**Review Comments**  
**Chase Bank ATM**  
**11004 Montgomery Blvd NE**  
**Traffic Circulation Layout**  
**Engineer's Stamp 07-02-2021 (G21-D018A(A))**

CHASEO
PLOT DATE
08/27/21
DRAWING SCALE
1" = 20'
PROJECT NUMBER
CDC21003
SHEET NUMBER
C1.02

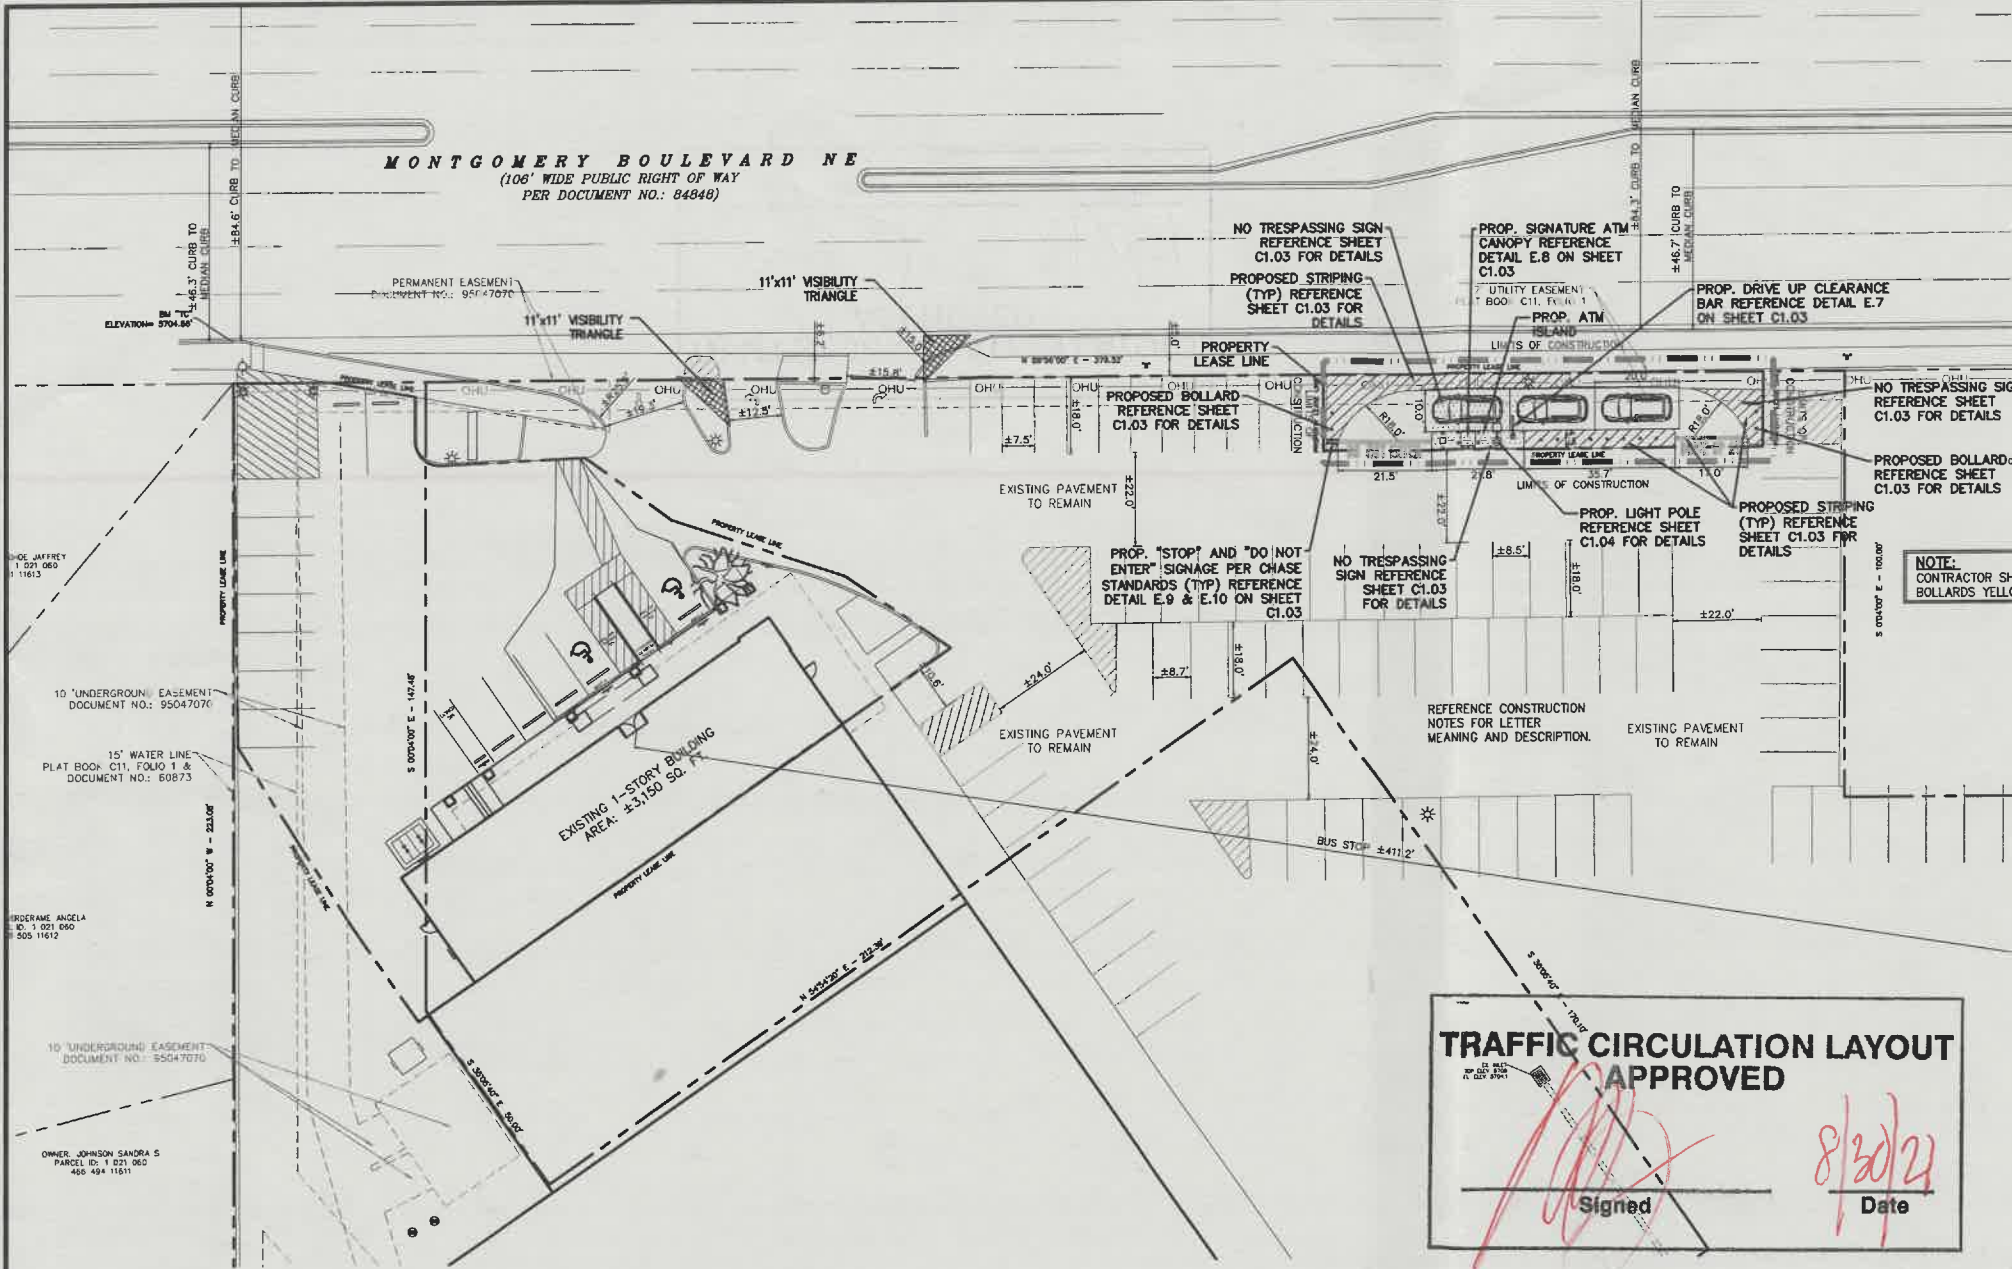
1. List the number of parking spaces required by the IDO as well as the proposed number of parking spaces including bicycle and motorcycle parking. Coordinate/discuss with Zoning with the calculations listed on site plan to substantiate the removal of parking stalls to construction ATM infrastructure.

**Response: Light pole details added to sheet C1.04**
8. Any problems with stacking over flow interfering with existing parking stalls and drive aisle? Please address.

**Response: Parking requirements table added to plans.**
2. Please provide the initial submittal fee receipt for this ATM project.  
**Response: Receipt added to submittal**

**Response: Vehicle stacking increased to 3 cars 10'x20'.**
9. Please provide a letter of response for all comments given.  
**Response: Response Letter to city comments provided.**

NO PARKING STRIPING DETAIL

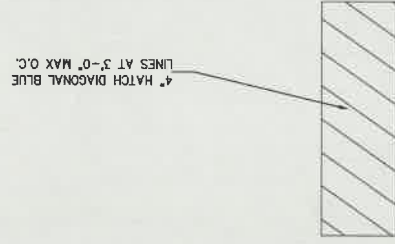
4. Provide a bollard detail proposed on sheet C1.02.  
**Response: Bollard detail added to sheet C1.02 and note to paint bollard yellow.**
5. All proposed striping will need details (stripe color, thickness & spacing between stripes).

**Response: Striping details added to details sheet.**
6. Any safety concern with free standing NO TRESPASSING sign without curbing on the departure of ATM. Please address this concern.

LIGHT POLE DETAILS

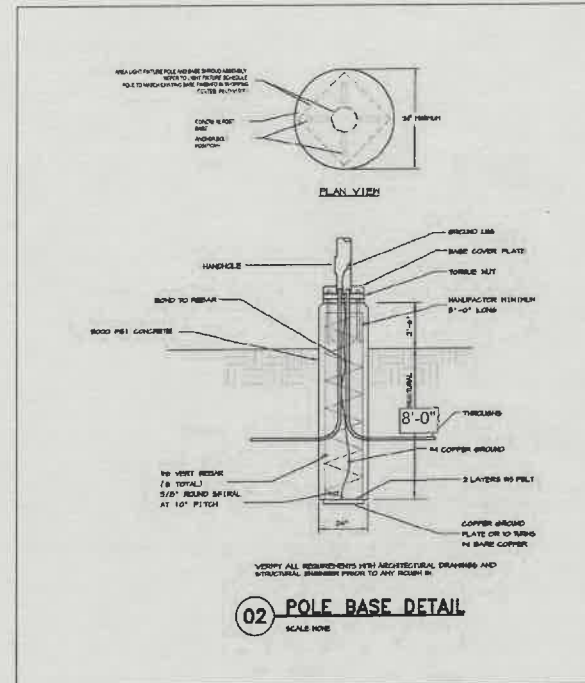
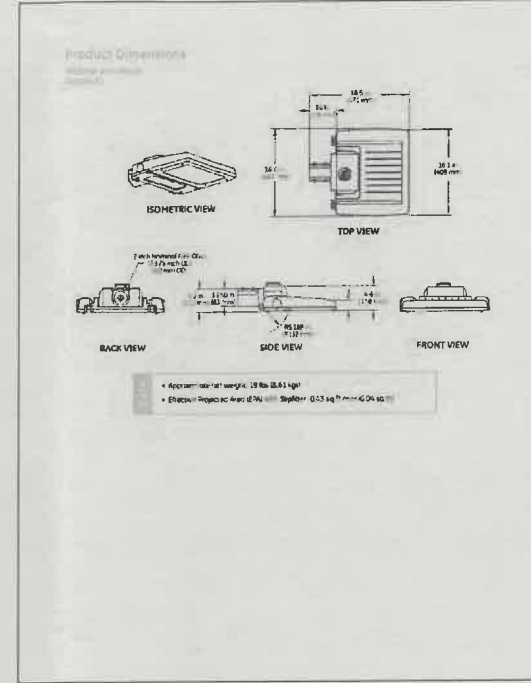
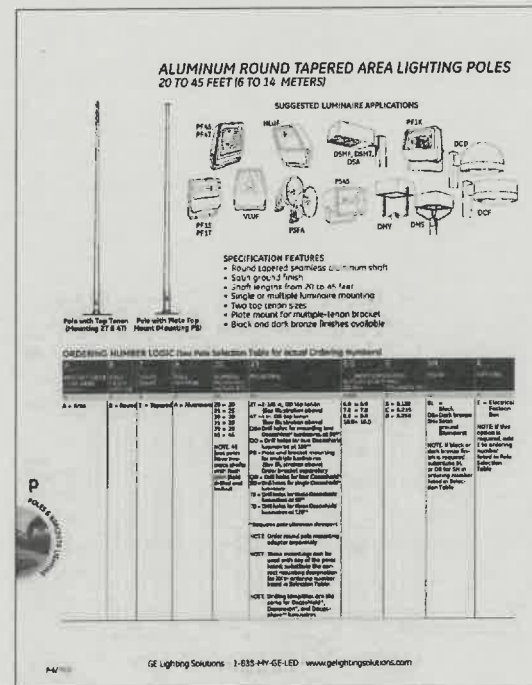
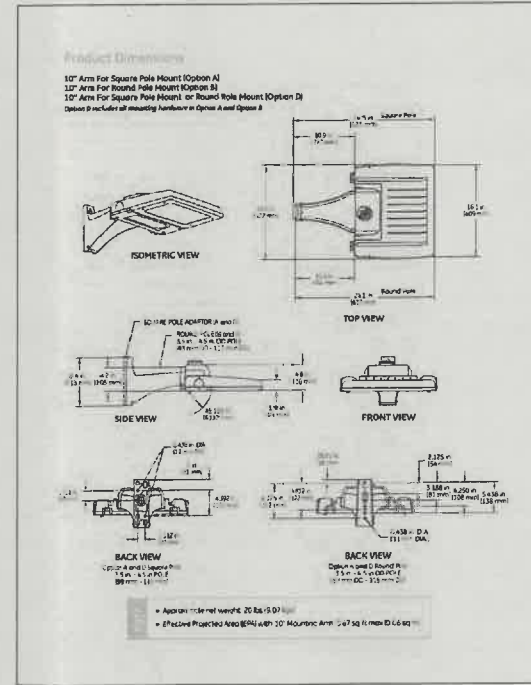
**Response: No trespassing sign removed from the departure area of the ATM.**
7. You have a symbol that appears to be light pole but no detail. Provide detail.
